PAQUETTE PLANNING ASSOCIATES LTD.
URBAN PLANNING AND LAND DEVELOPMENT CONSULTANTS

Re: Zoning By-law Amendment D02-02-21-0008 and Site Plan Control D07-12-21-0015
120 Den Hagg Drive
Phase 1

Circulation Comments and Responses

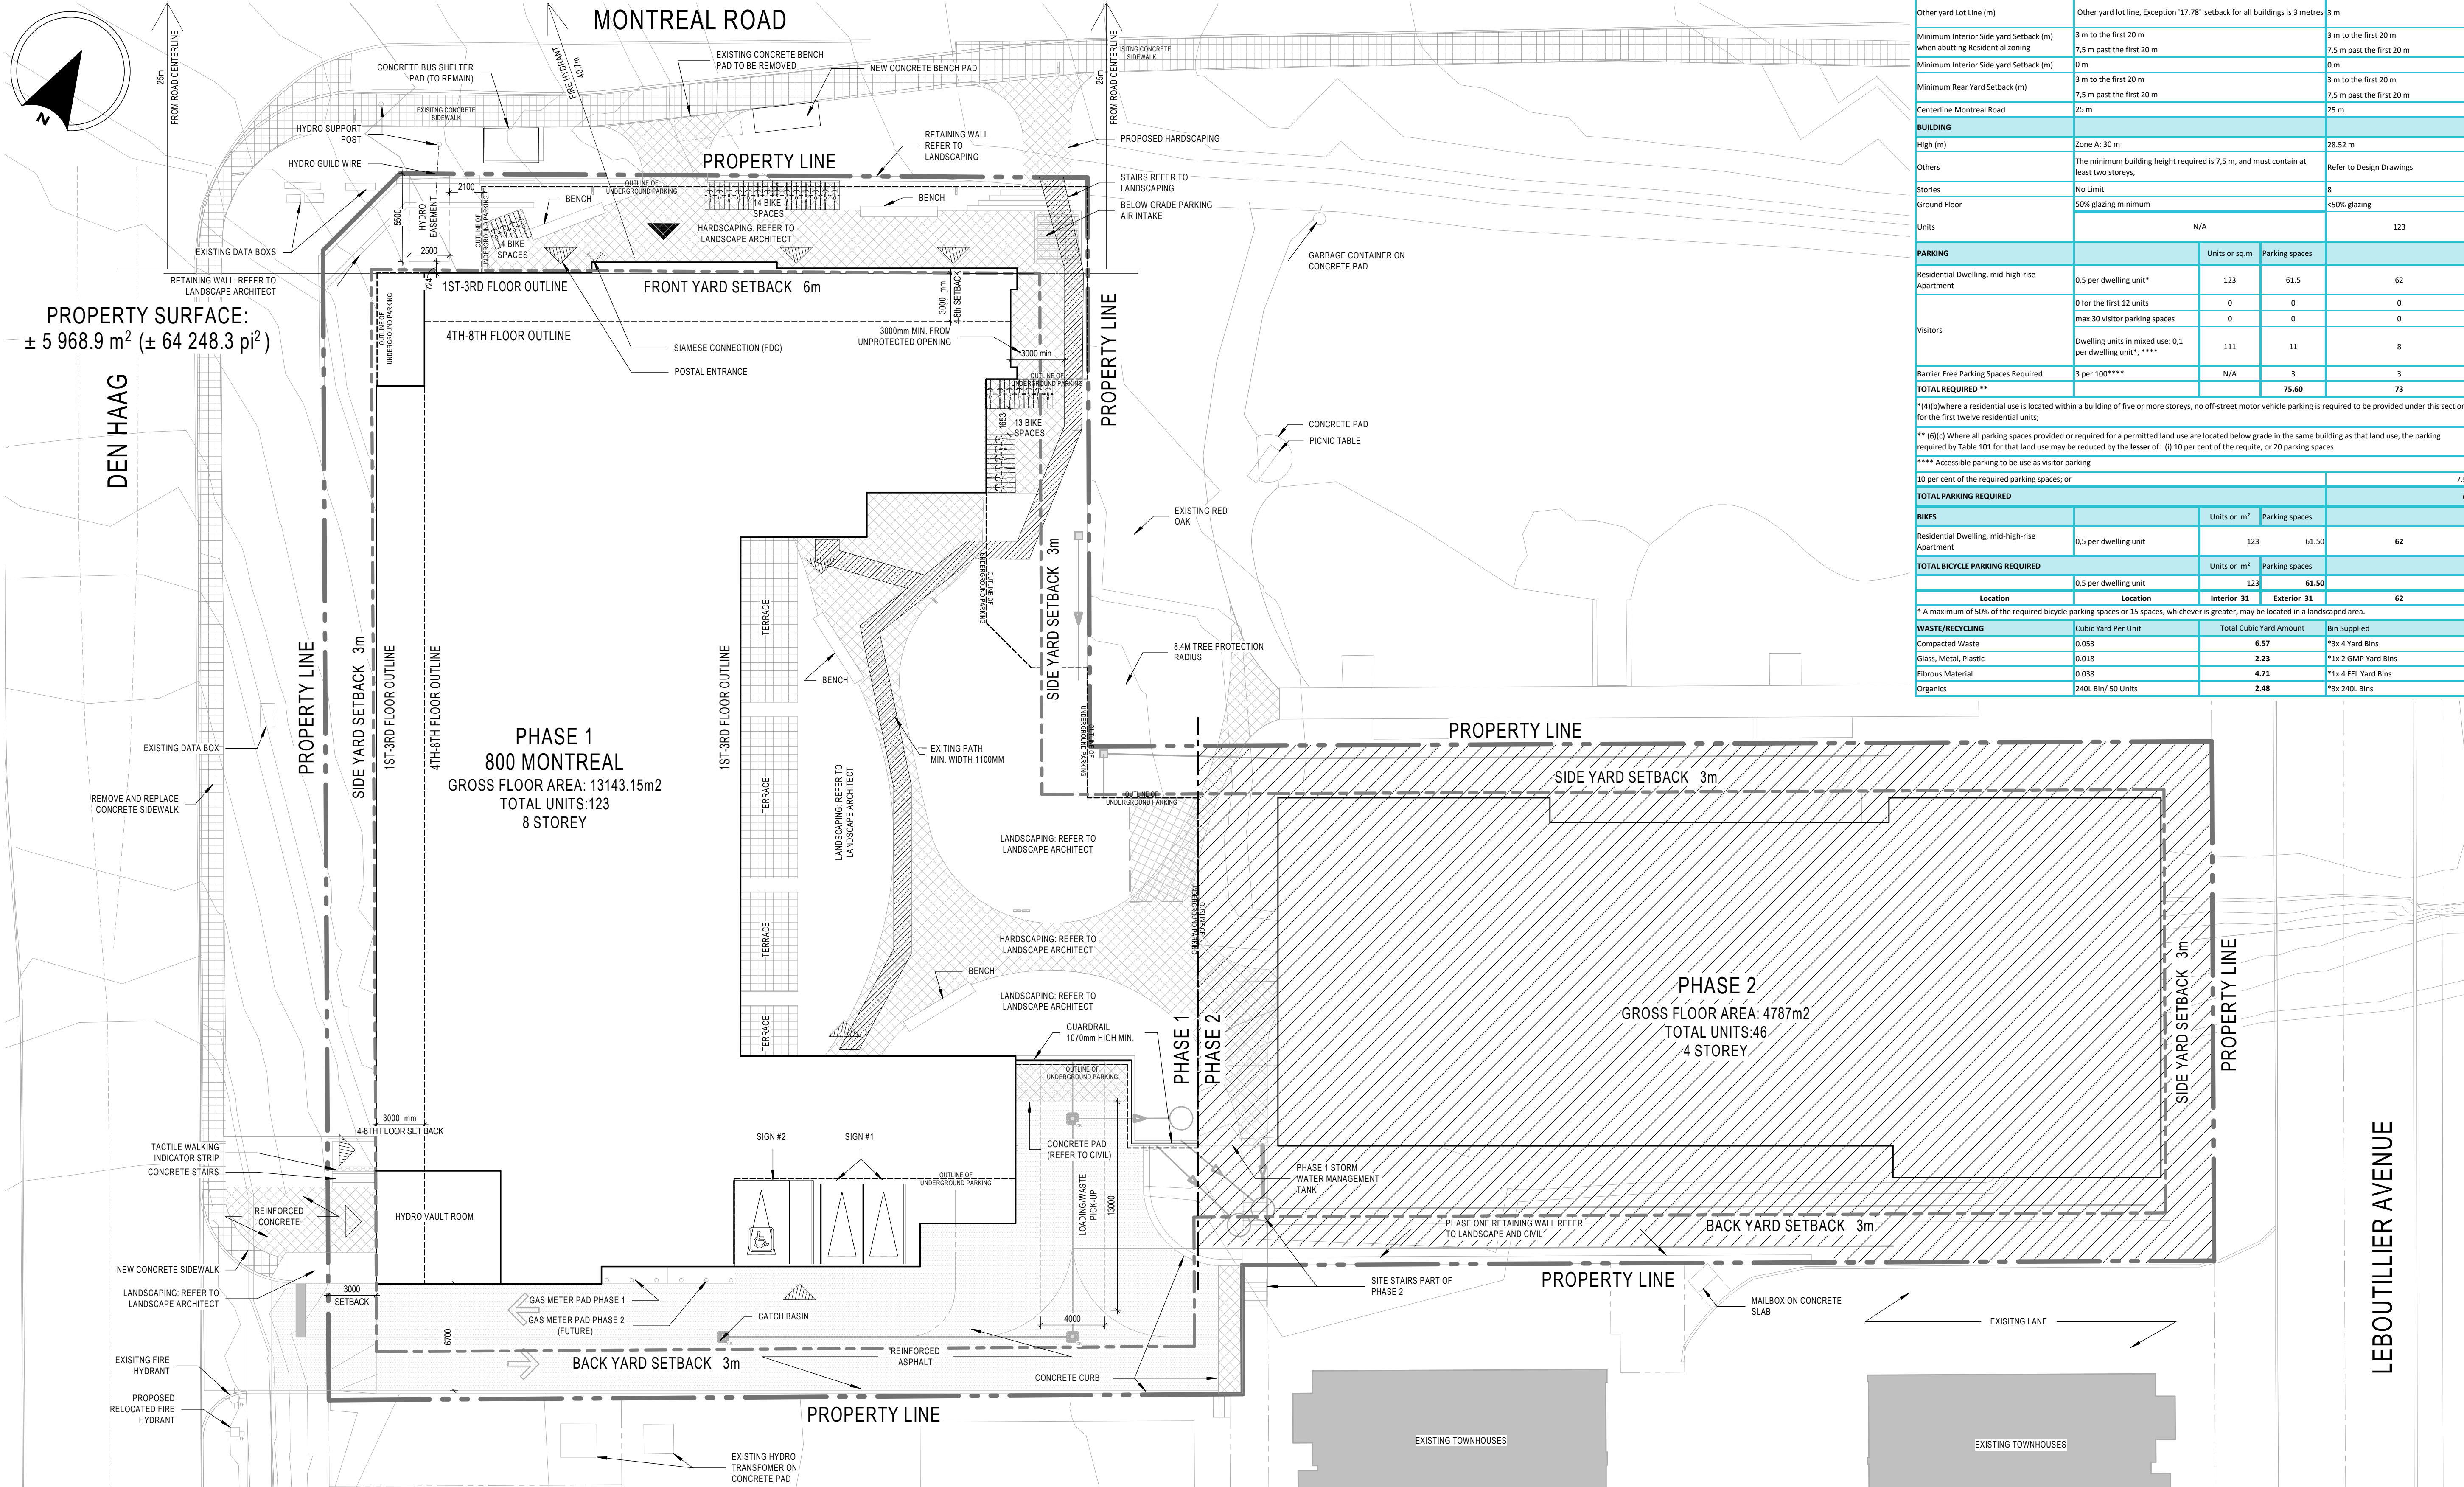
1. The eastern sidewalk along Den Haag is in disrepair with some grading issues noted. Please include the repair in the scope of works.

7. The civil plans include the following note on the Montreal Road frontage: “concrete pad and bench to be removed and disposed offsite”. Confirm this is the preference of Transit Services. Consider relocating rather than entirely removing. Also consult with Transit Services on the preferred location of the bus shelter pad.

8. The civil and landscape plans show the sidewalk on the east side of Den Haag Drive and the north side of the access as being reconstructed in interlock paving. The

sidewalk must be constructed in concrete per City of Ottawa standards.

9. The civil plans show depressed curbs across the sidewalk. Note that City of Ottawa standard detail SC7.1 does not include depressed curbs across the sidewalk (i.e., the sidewalk is flush concrete, and the private approach curb is completely discontinuous when it crosses the sidewalk).

10. Private Approach should be 3m from side lot line. Per Section 25 (1) (p) and Section 25 (1) (r) of Private Approach By-Law, it is permissible to reduce the setback. However, the proponent must provide the rationale for a reduced setback and confirm the conditions of Section 25 (1) (p) have been met. Also note that no part of the Private Approach (e.g., the curb return) shall be permitted to encroach across the projection of the side lot line.

- Can you have Neuf include the provided corner side yard setback along with the provided step back (for the 4th-8th floors) on the Site Plan? Also include this for the Montreal side too.

- The Site Plan should include a zoning compliance table – this is required to understand the zoning in place at the time of approval. The chart you’ve provided separately is not an approvable document.

Please dimension bicycle lockups interior and exterior: space width and lengths, as well as aisle width. Ensure that it complies with Sec. 111.

- Include the number of bike lockups in each location on the site plan as it is on the landscape plan.

Response: Noted. Sidewalk to be added to scope of work for 120 Den Haag. Existing sidewalk to be removed and replaced in existing location based of city's standard details.

Response: Noted, Existing concrete are to be removed and new concrete pad provided. Transit Services stated. See attached email from David Hook of IBI dated April 24,2023 regarding concrete pad and bench.

Response: The interlock has been removed, and concrete side is to be provided. See attached site plan.

Response: Site plan reflects SC7.1 design.

Response: Building placement and design layout is based off on the masterplaning originally designed by HOK and Canada Lands.

Although the Private Approach By-law requires that approaches must be at least 3.0m from the abutting property line, the proposed offset of 0.3m is recommended for City approval as it will not result in negative impacts to the adjacent property (140 Den Haag Drive), a new mid-rise development with no vehicular access on this street. The proposed access location can be safely accommodated and will not result in traffic hazards with the adjacent property, is located a sufficient distance from the nearest intersection street (LeBoutillier Avenue) and does not result in any sight line restrictions based on the established building setbacks. The curb radius is proposed to extend beyond the southern property limit, however this poses no hazard to the adjacent residential development at 140 Den Haag Drive.

Response: Added, please see updated site plan attached.

Response: Added, please see updated site plan attached.

Response: See attached site plan. 1500mm MIN. clearance provided.

Response: See attached site plan with zoning compliance chart.
